ENG-CDR19004-R2-TIS-Redlines.pdf Markup Summary

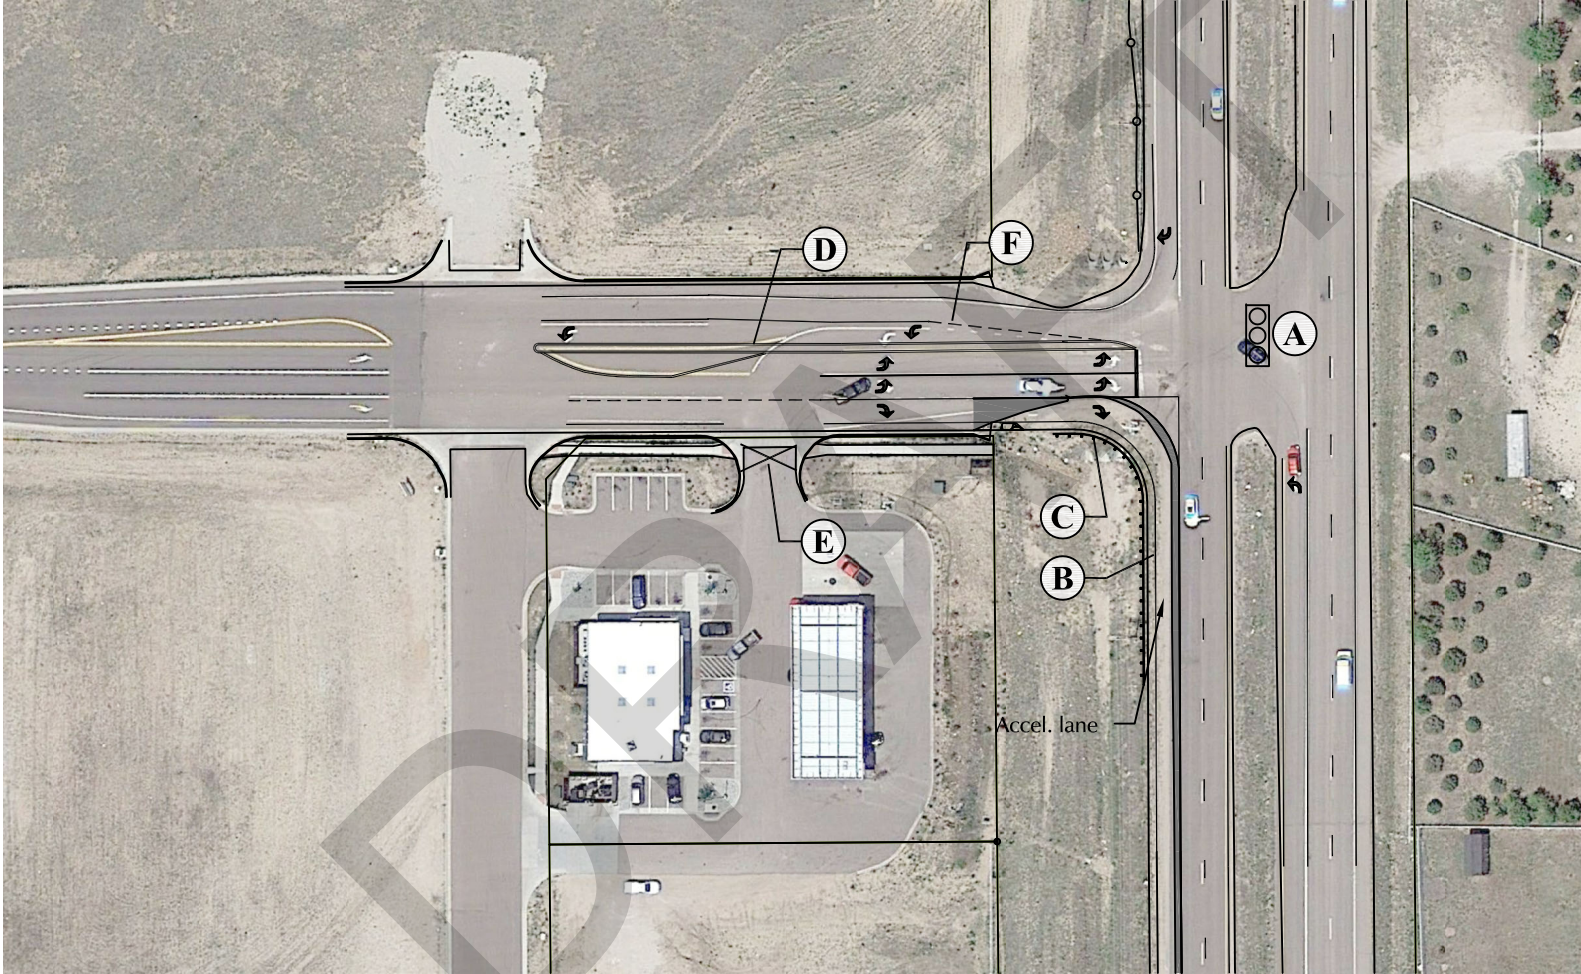
: projected maximum eastbound left-turn
Meridian Road is 128 feet. The maximum
Drive is 130 feet. These queues could be
trapezoid shown in Figure 11.
raised island?
on Meridian Road approaching Bent Grass
left-turn lane at this intersection is about

raised island?

See comment letter regarding SB right turn at
BGM Dr. and ECM Figure 2-27 (provide).
